The North Falls Offshore Wind Farm project (EN010119)

Babergh District Council submission to procedural deadline 2

This is the submission of Babergh District Council to deadline 2 of the examination for the North Falls Offshore Wind Farm project (EN010119) consisting of Babergh District Councils' responses to ExQ1.

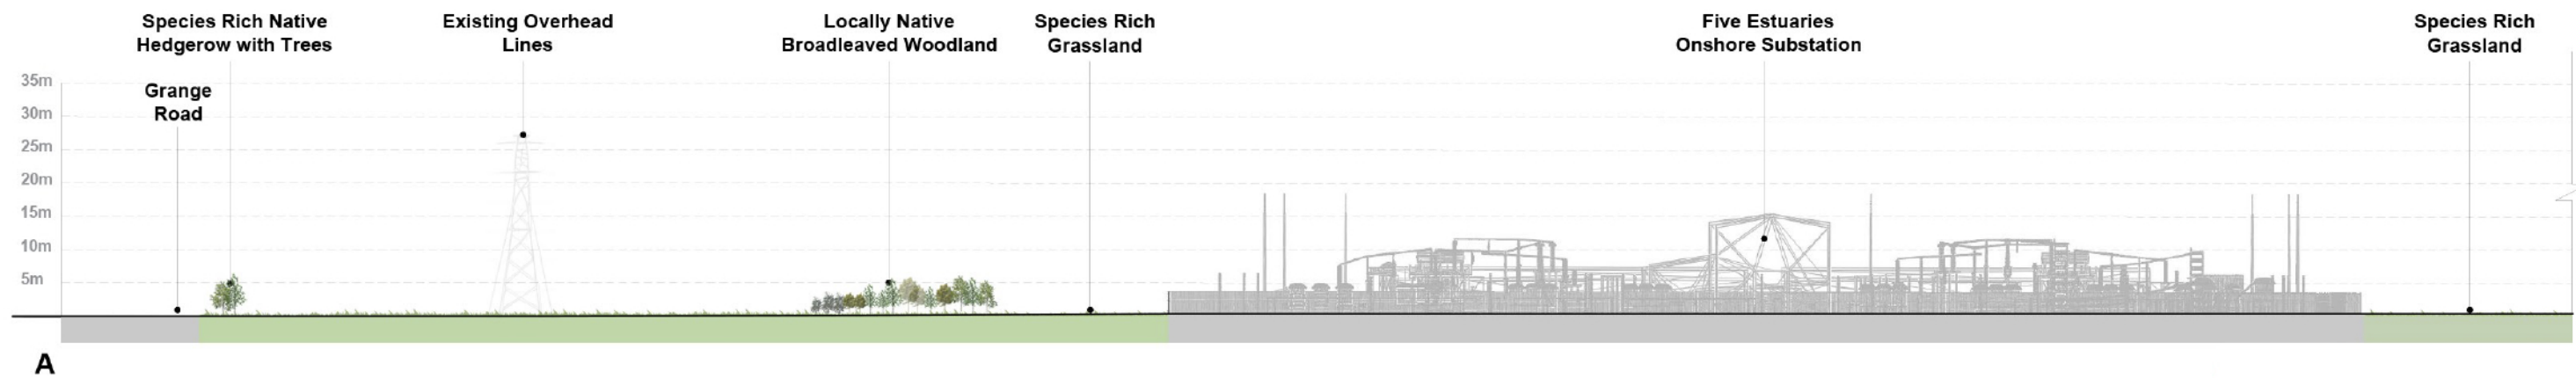
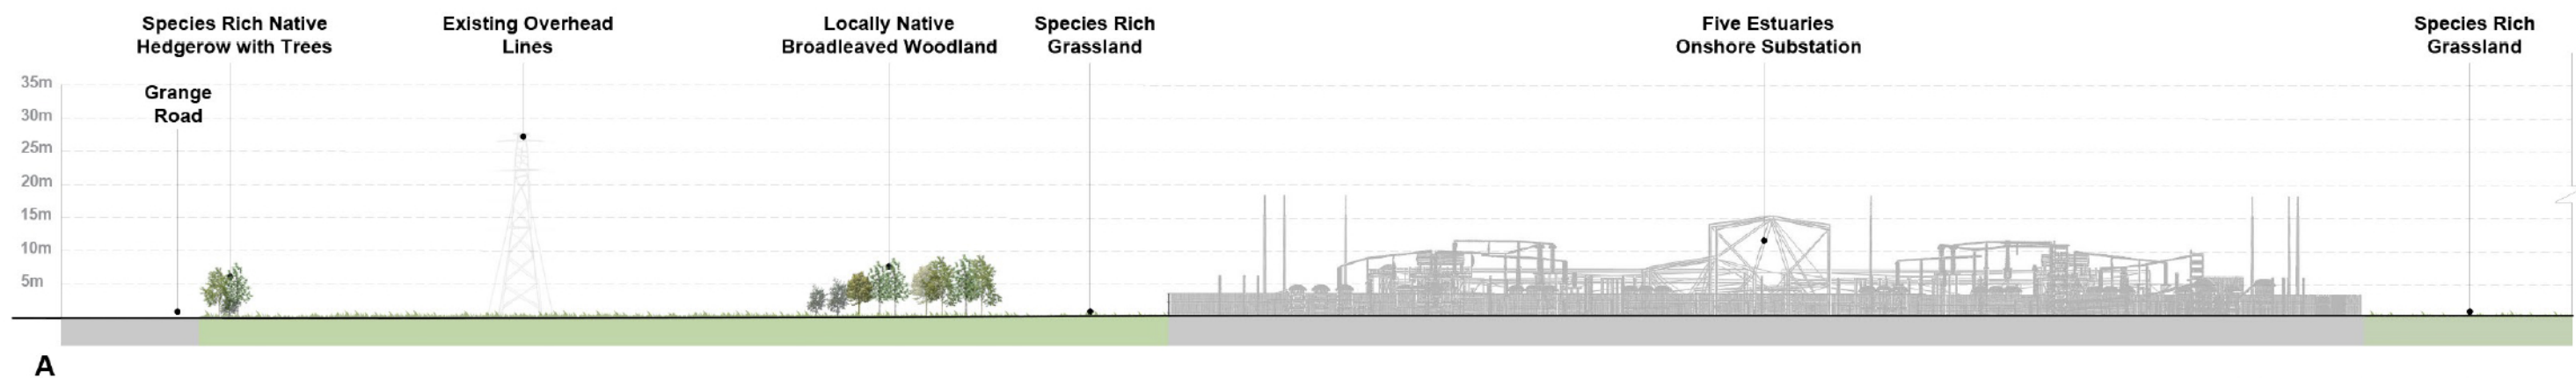
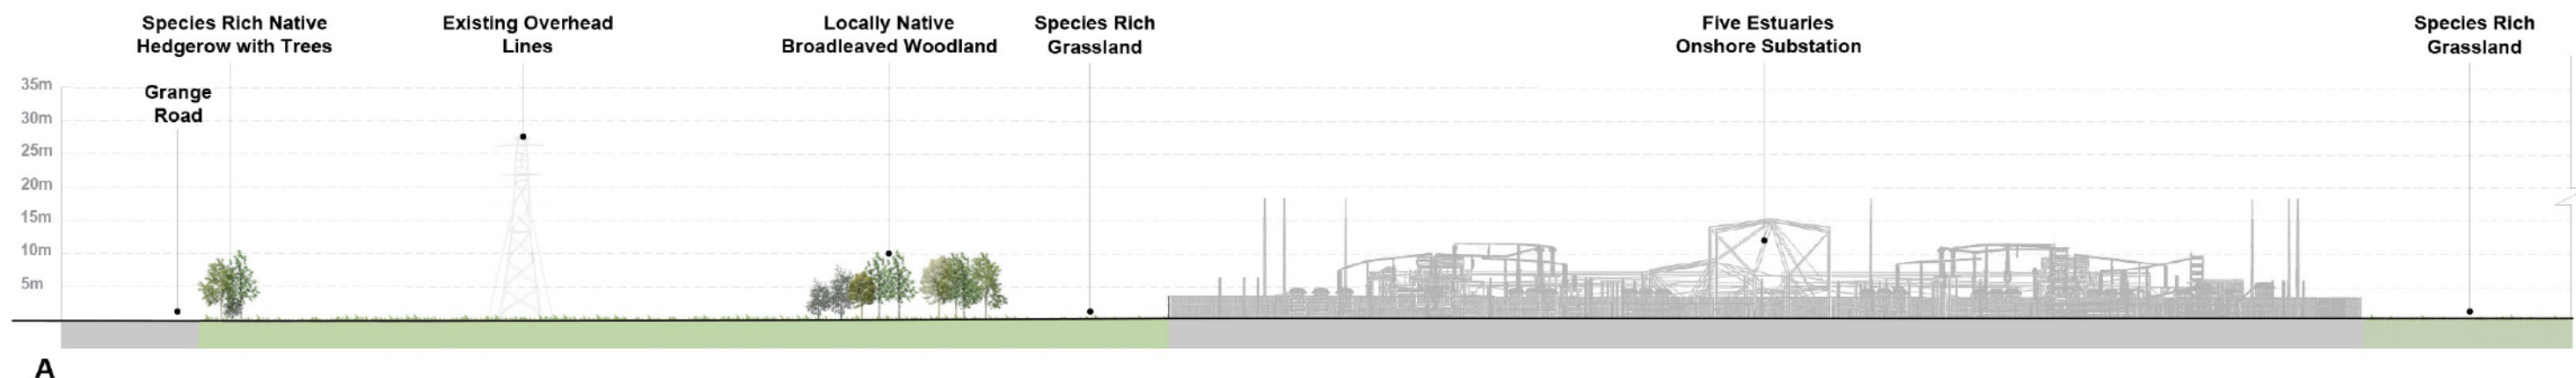
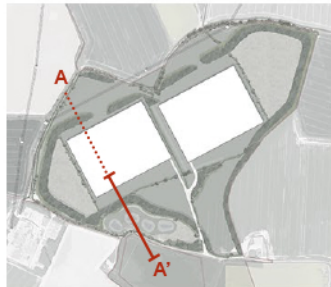
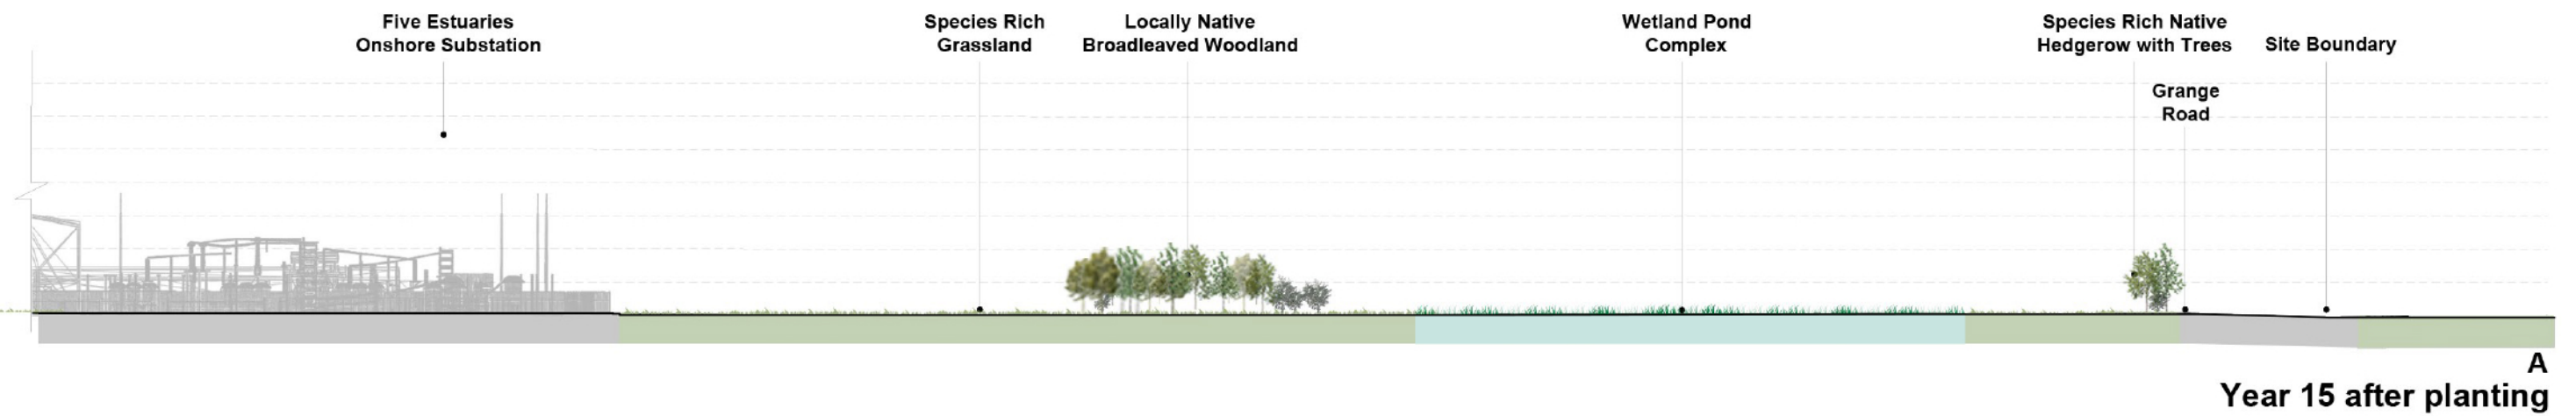
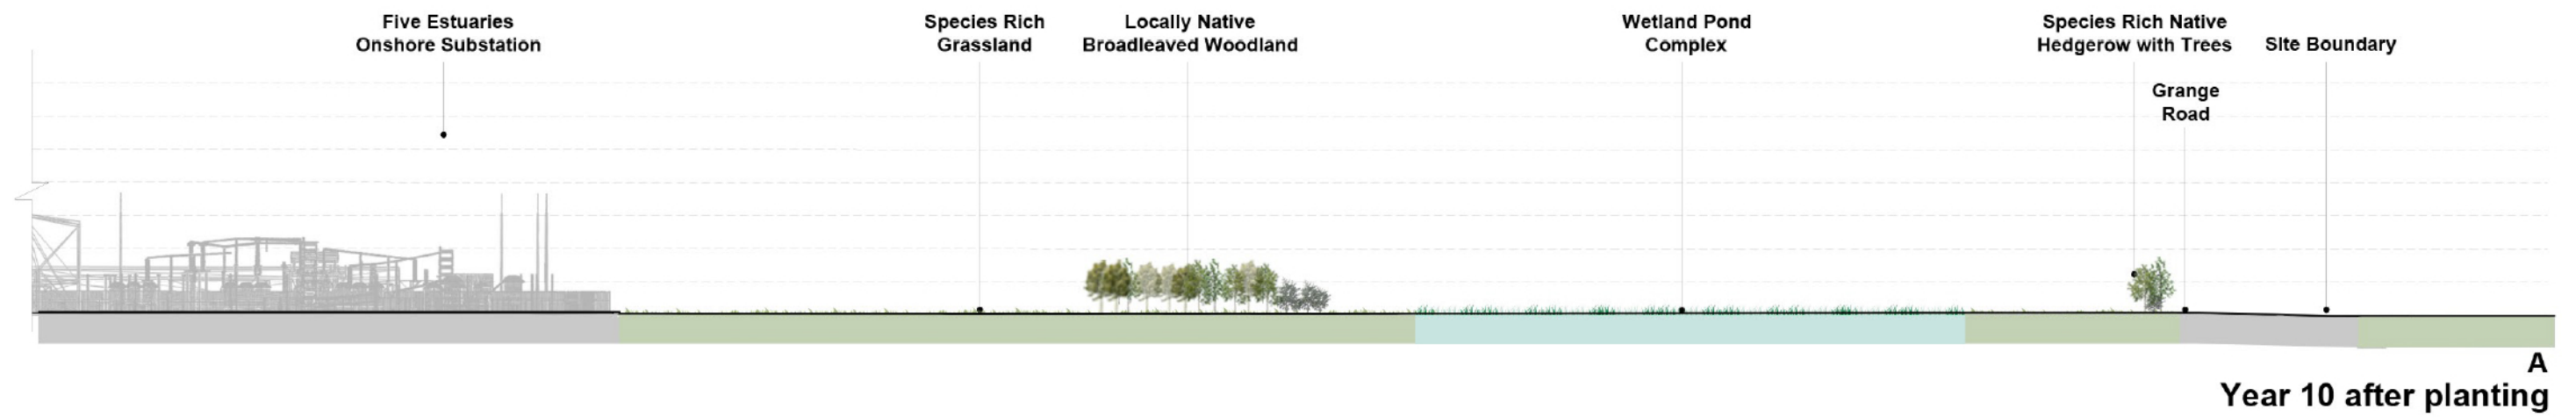
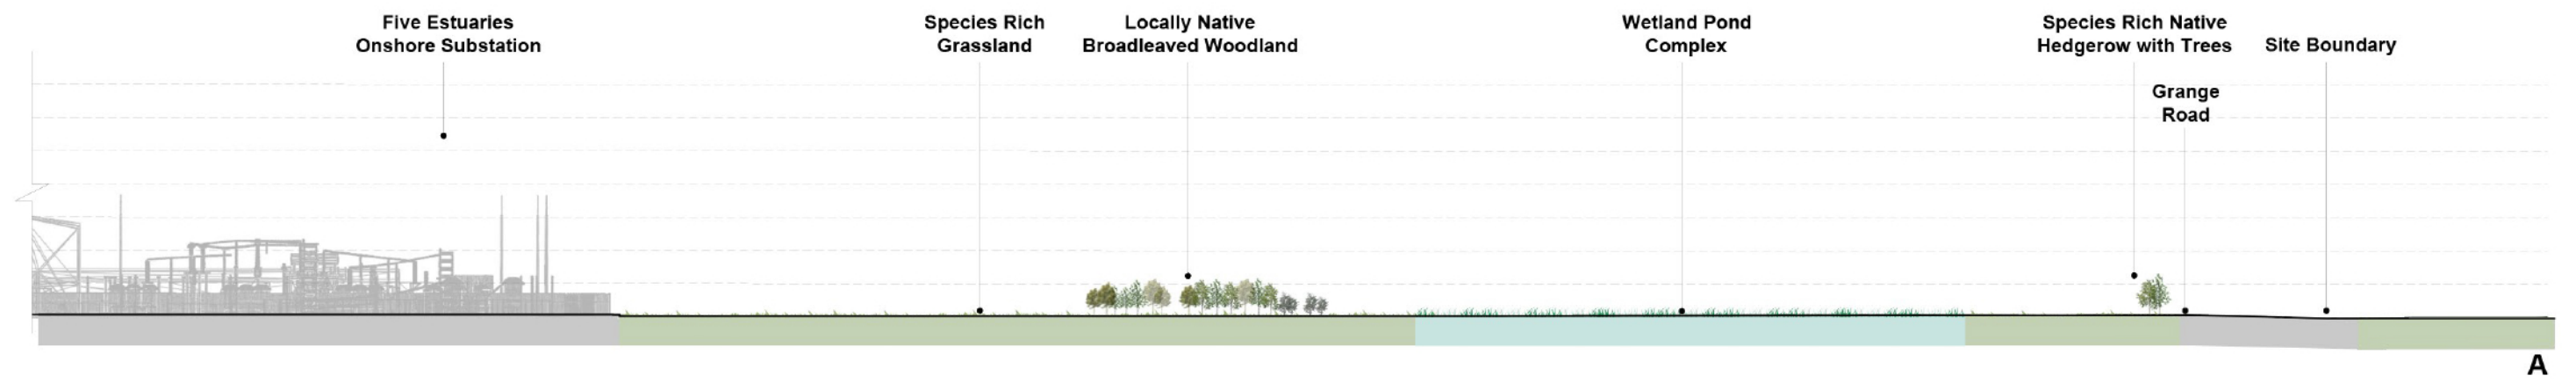
The cross-section BB' and GG' on Pages 39 and 40 demonstrate that the top of the installation could still be visible once the vegetation has matured. Cross sections CC' and EE' do not show the installation so are of limited value. Sections DD' and FF' do not show the position or scale of any visual receptors so are of limited value.

# **Onshore Substation Zone of Theoretical Visibility and Viewpoint Locations with Dedham Vale National Landscape**

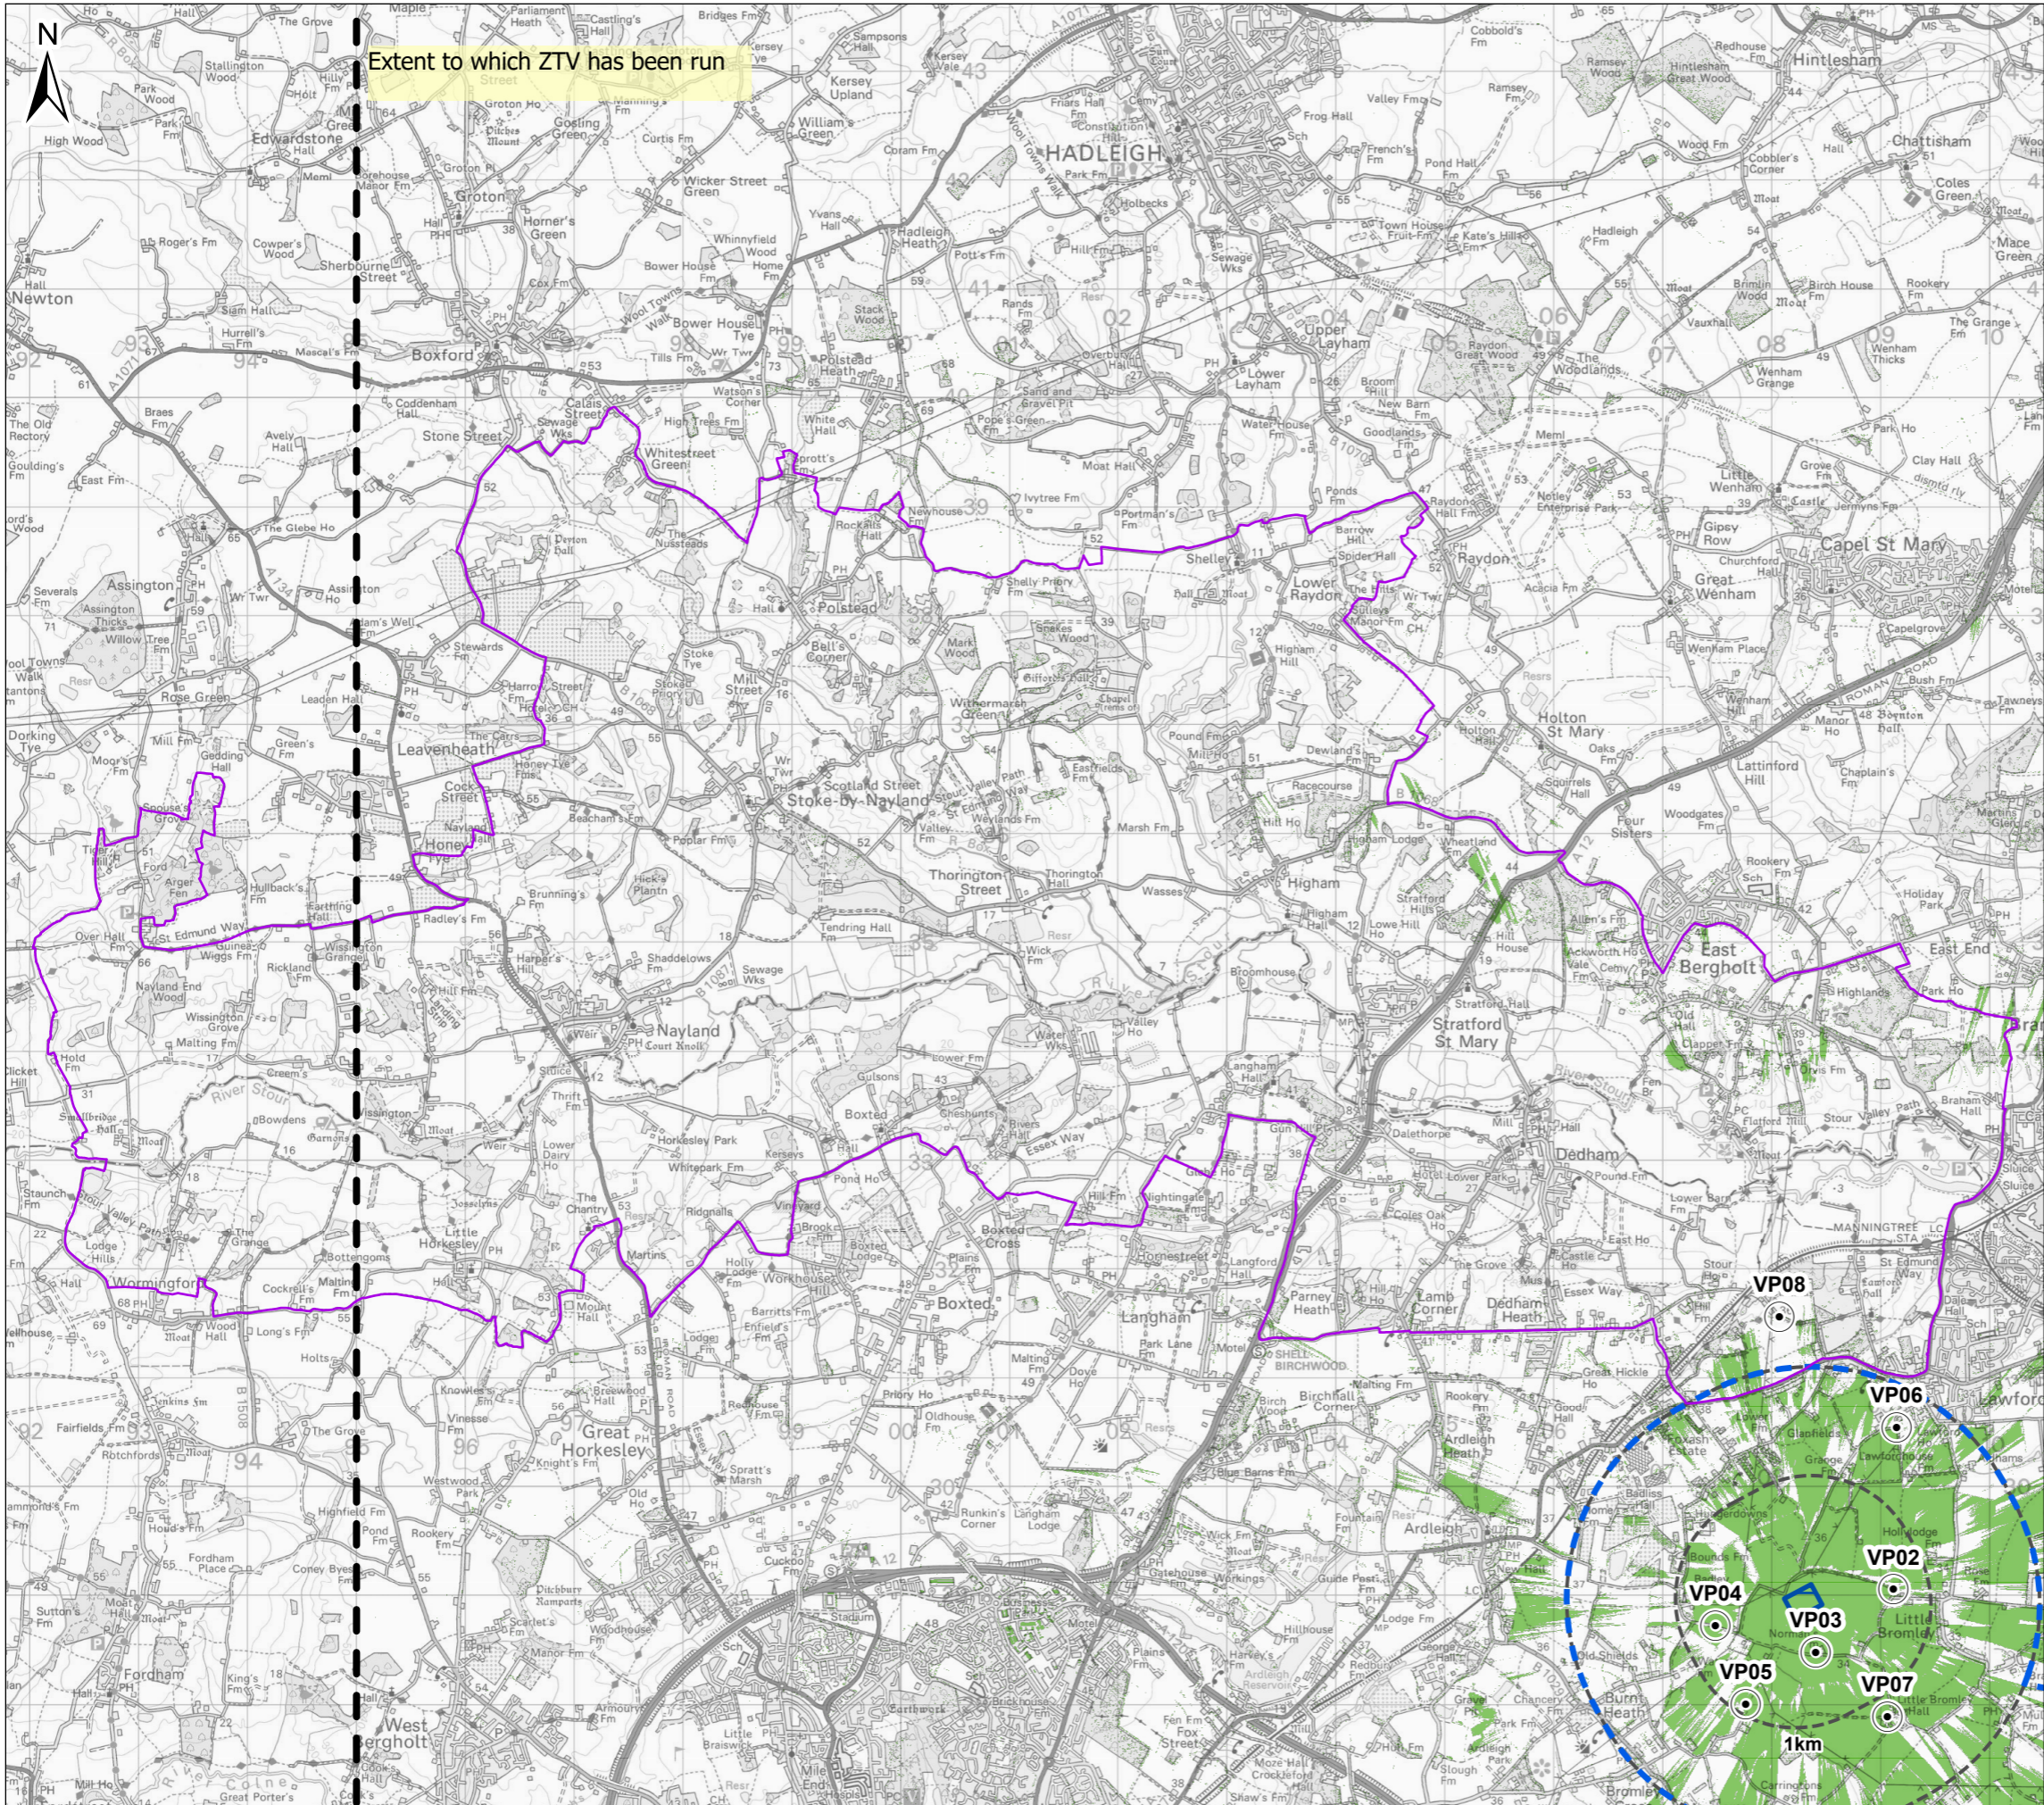
Whilst the ES document figures identify the ZTV in relation to the proposed viewpoints, *Figure 30.1.2, Substation Zone of Theoretical Visibility (18m in height)* and Viewpoint Locations they do not identify either in relation to the boundaries of the AONB/National Landscapes. The

AONB/National Landscapes are shown on *Figure 30.1.4, Designated Landscapes*. However, this figure truncates the Dedham Vale AONB/National Landscape in the west/North-West, so an additional figure centred on the ONSSS is required with the AONB/National Landscapes overlying the ZTV and viewpoint locations.
